From: Simon Davis
Sent: 17 November 2021 18:20
To: 'Havis, Sean' [REDACTED]
Cc: Sparkes, Jessica [REDACTED]
Subject: RE: *EXTERNAL: Drove Lane Sales Cabin refs Y/141/21/PL and Y/142/21/A

Client: Barratt Southern Counties
Site: Ryebank Gate
Job No: Q80195 v4
Date: 24/05/2021
Designer: SM

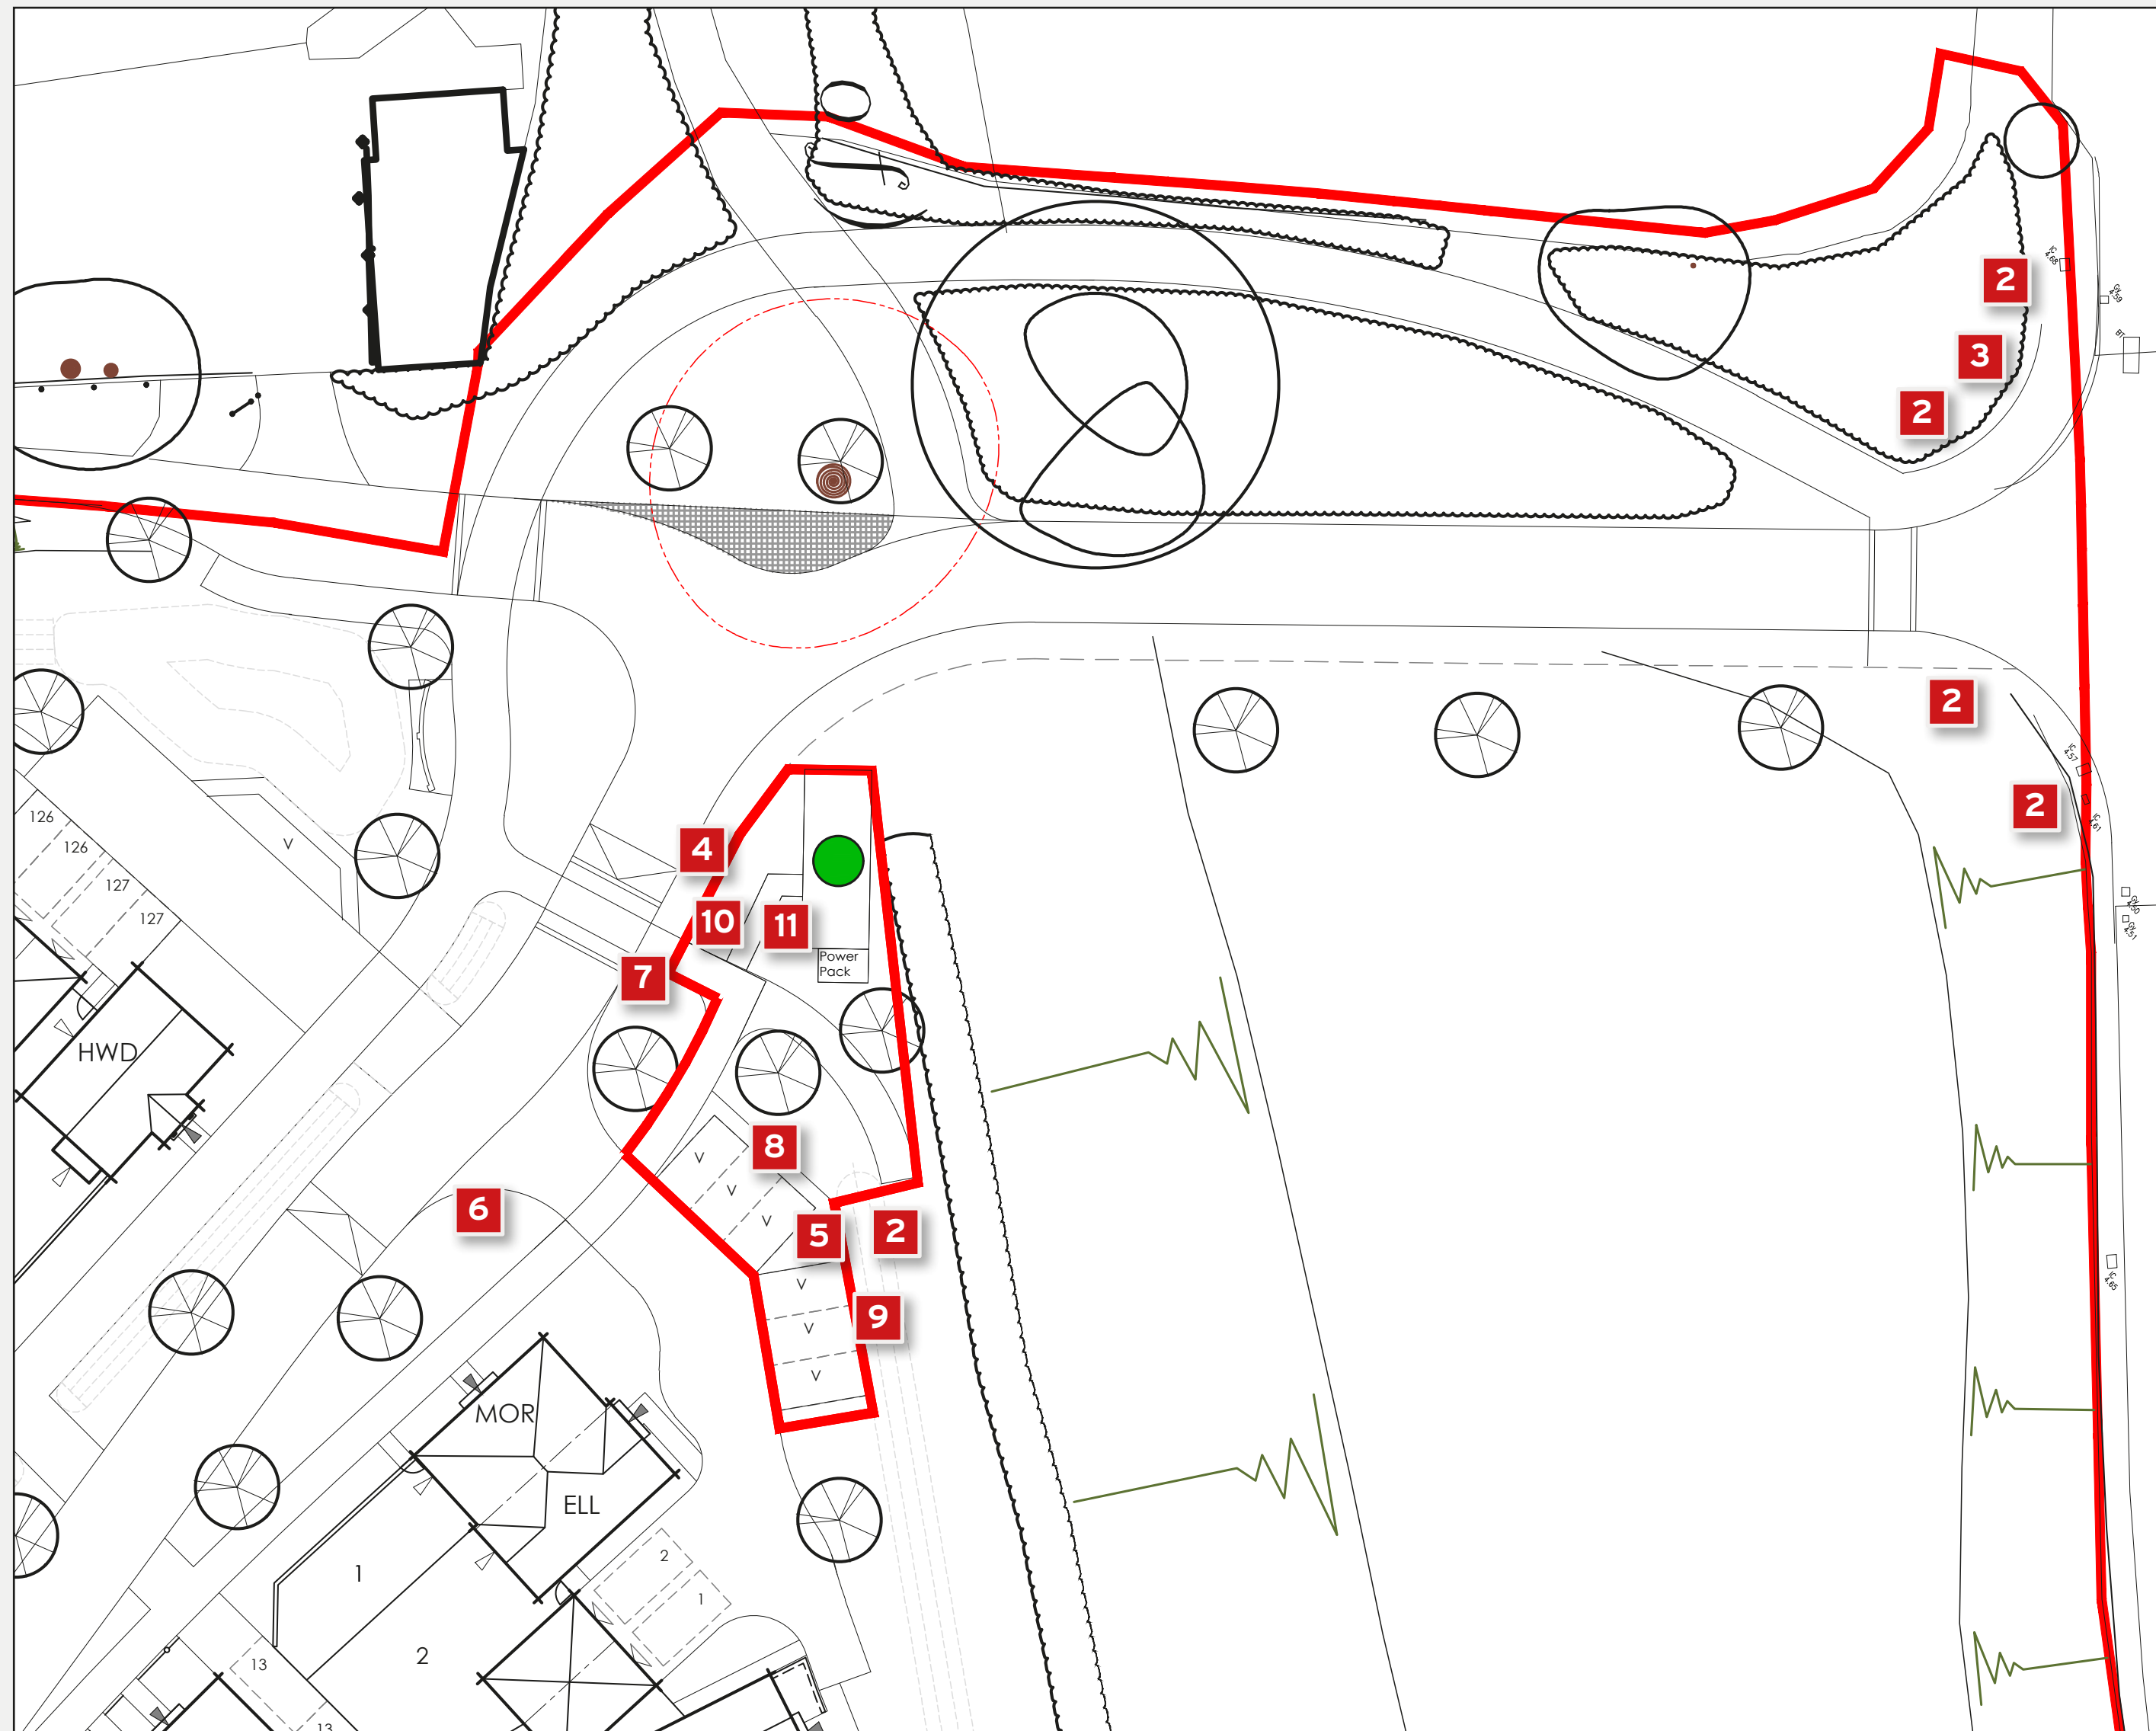
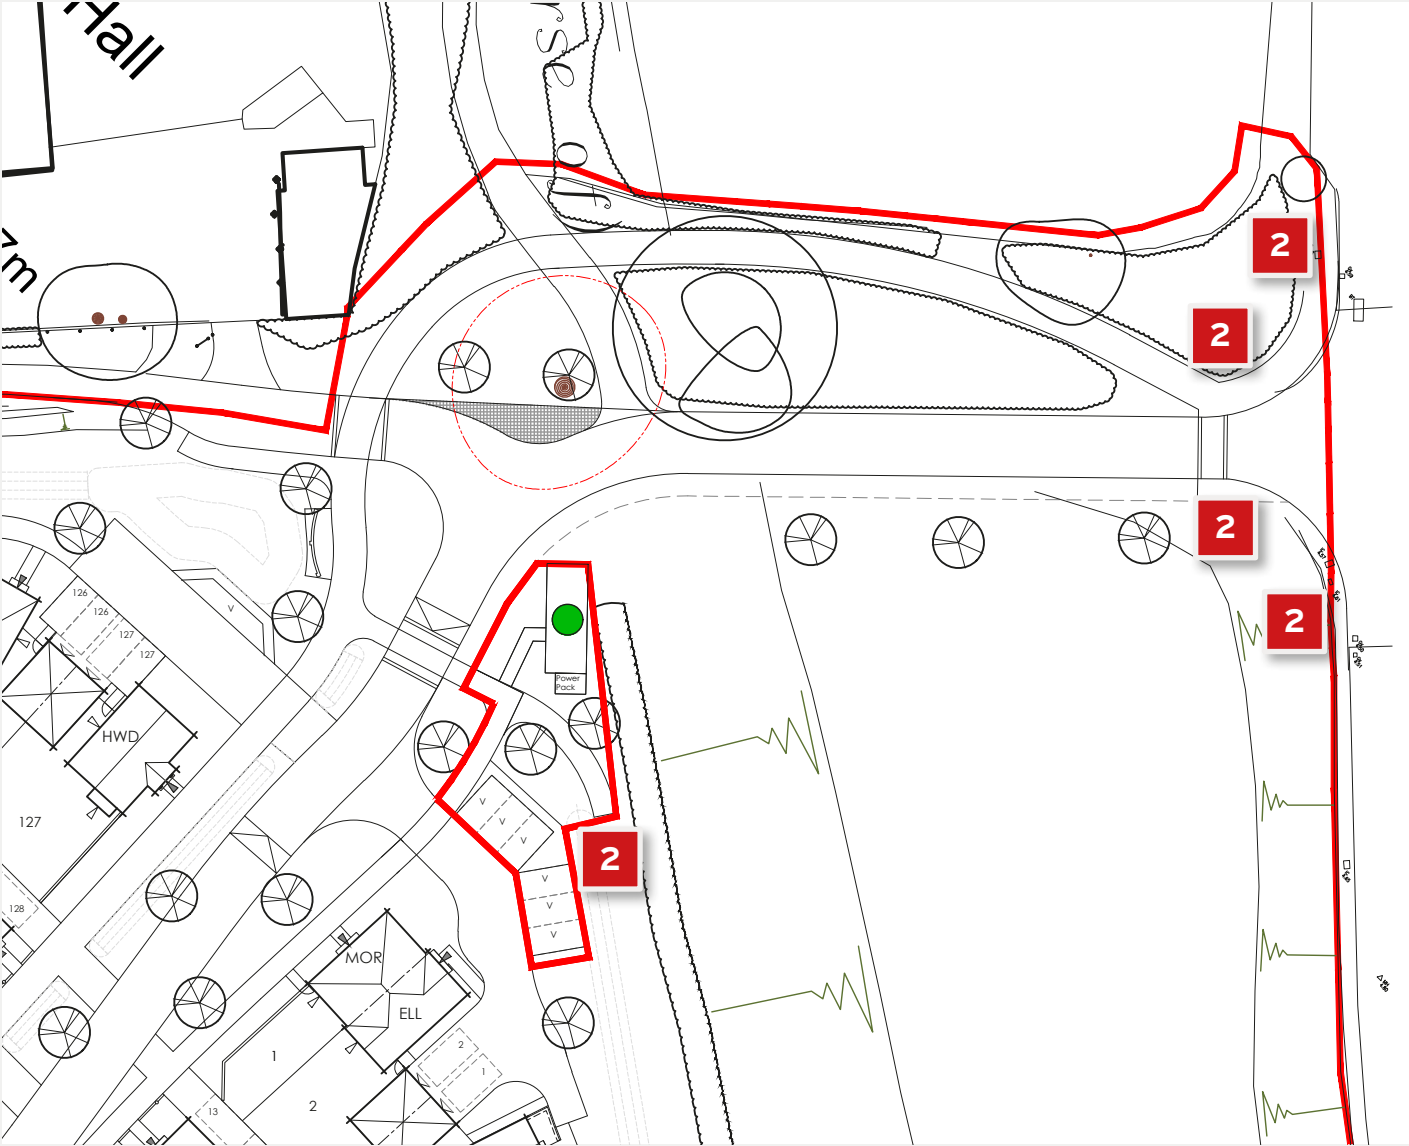
I will write up Y/142/21/A for approval and include a condition to secure the wood effect flag posts that I had requested but can you agree an extension of time on this application until 19/11/21 please as it went out of date yesterday.

Therefore, yes, the only other matter outstanding is Ecology (and the timber effect posts for the advert app)

I hope to have an updated plan across to you by CoP tomorrow which re-orientates the cabin slightly to ensure that it provides ample room to the footpath. We are also updating the advertising plan to remove flags at the front of the site and replace with 2 no totem signs. I hope that this will resolve both the Parish Council's and your Conservation Officer's concerns regarding the flags and also alleviate the concerns regarding the footpath.

Drawing Title:
SALES AREAS 01

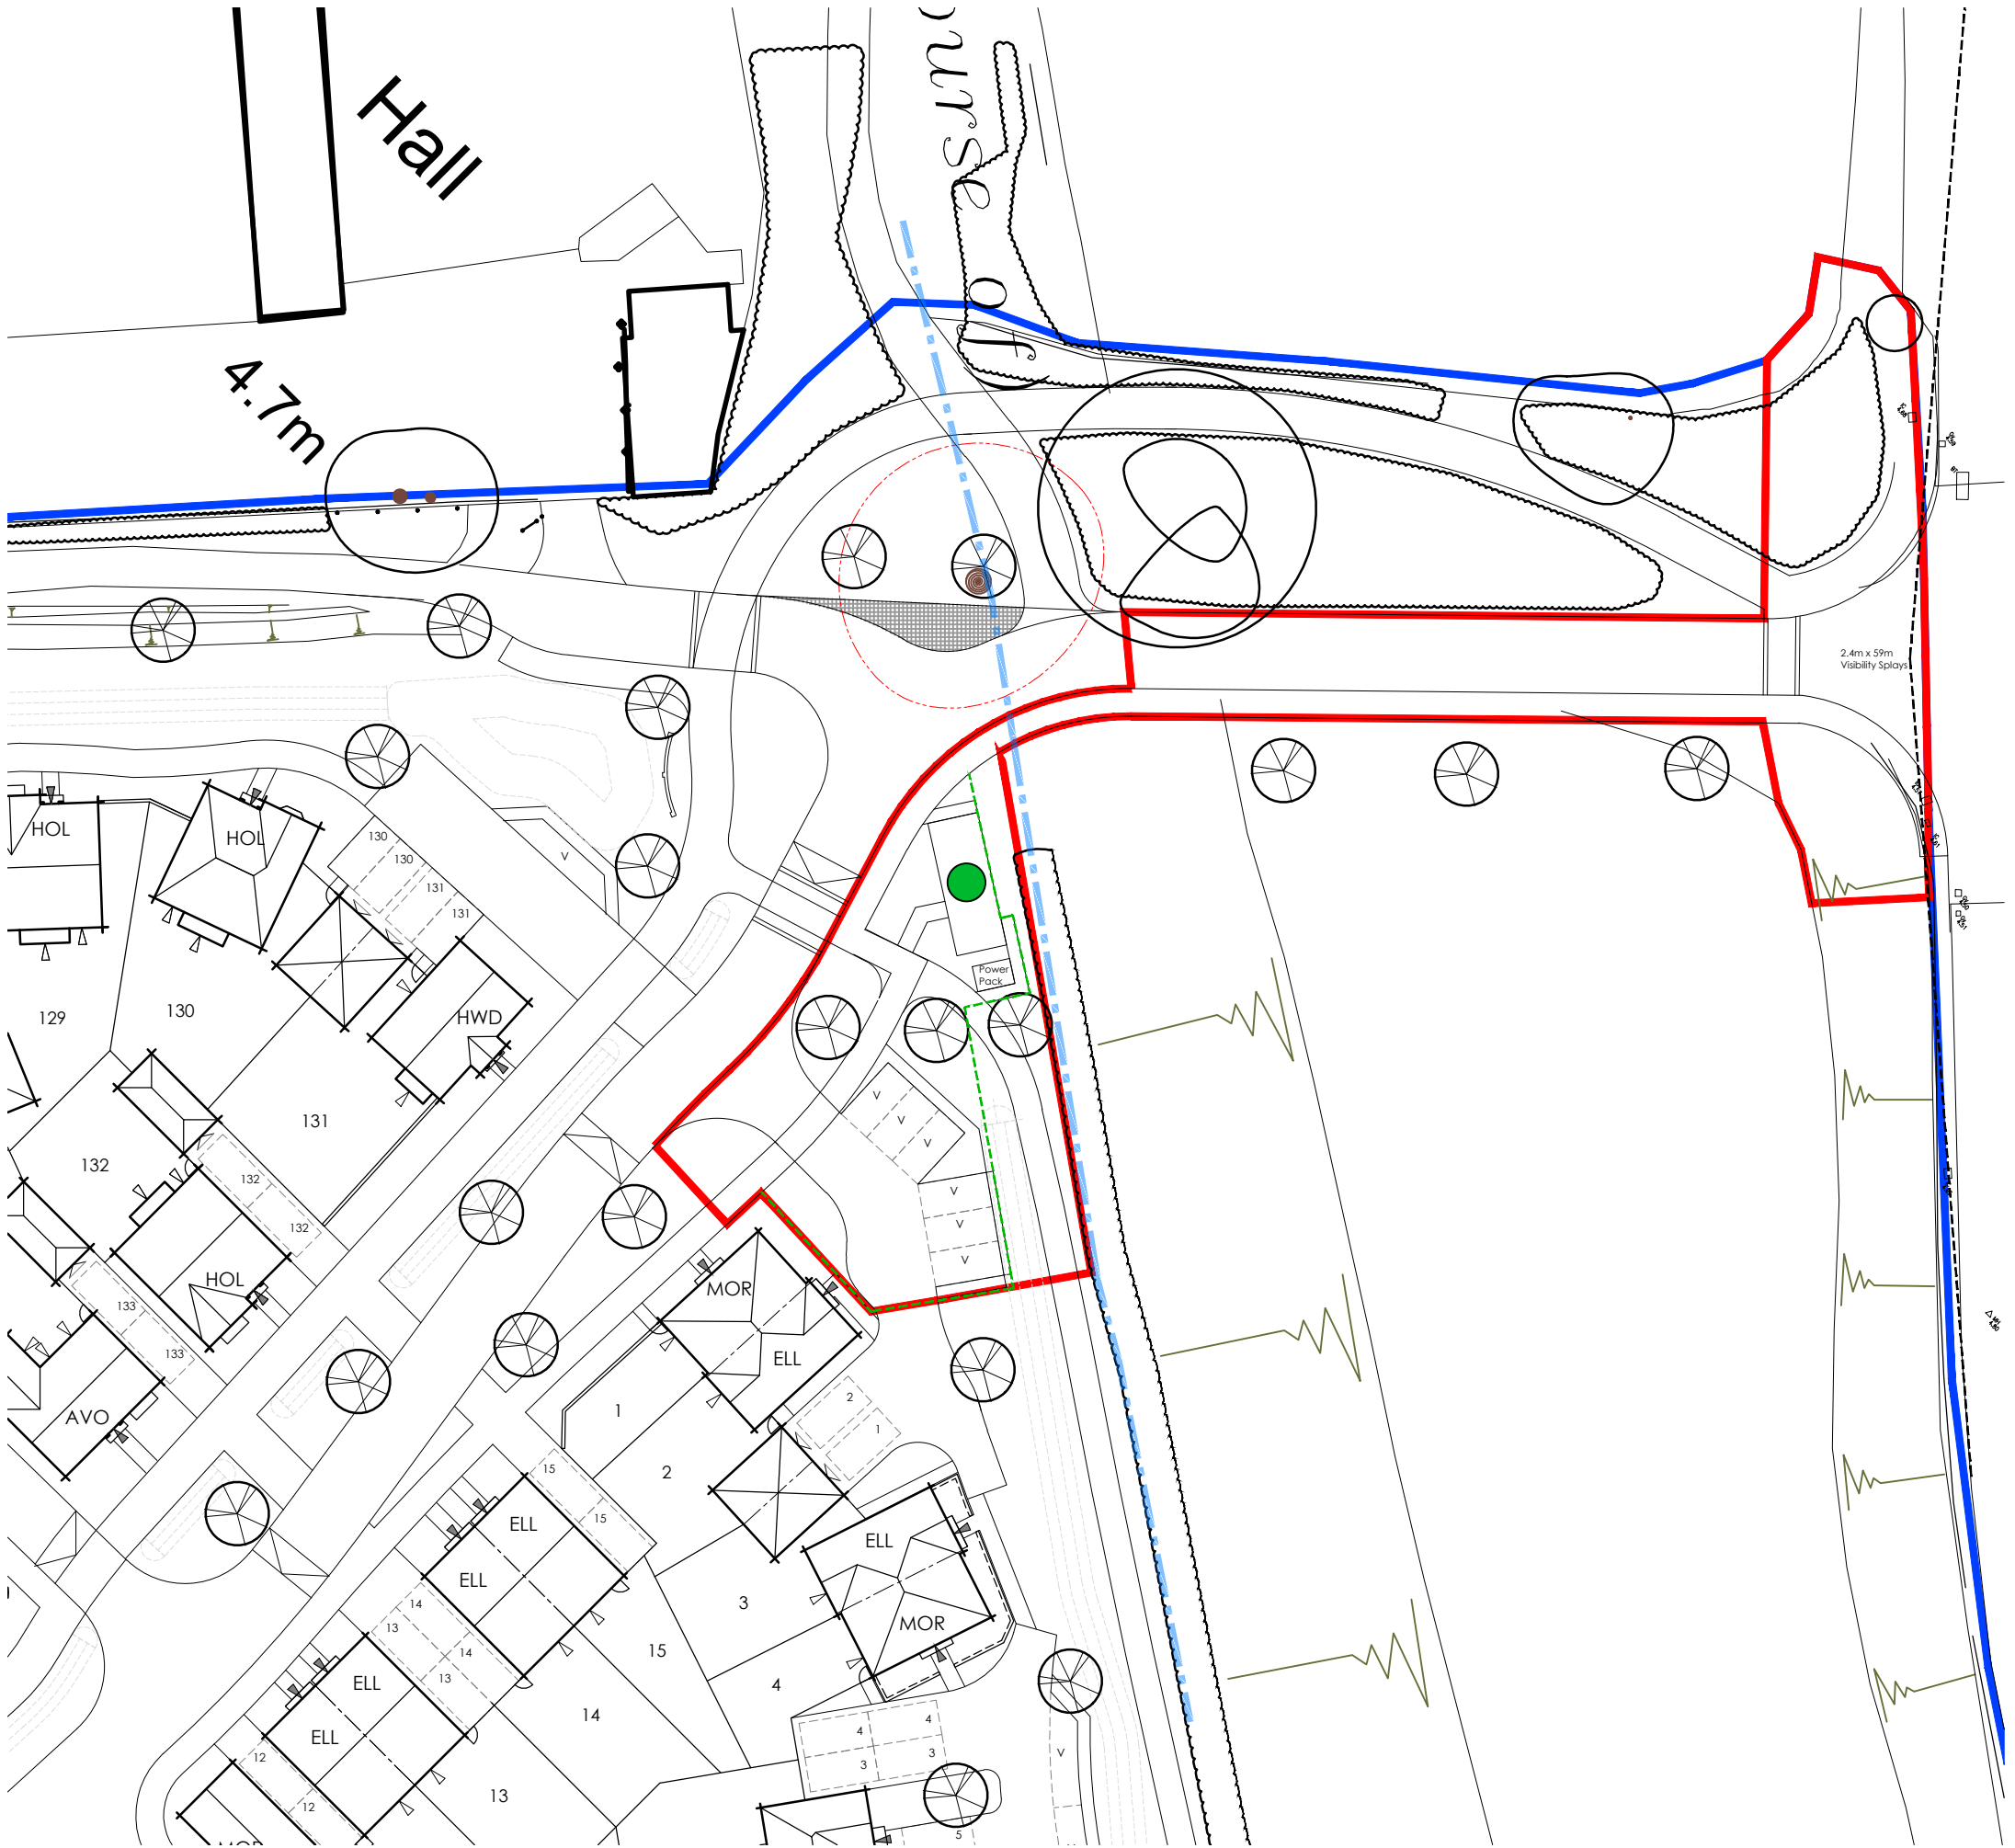
Thanks for this and I await the revised plan that you refer to or if you are not doing this then further assurances of no impact to the line of the footpath. I have liaised further with WSCC PRoW and they are very keen that this point is resolved to their satisfaction.
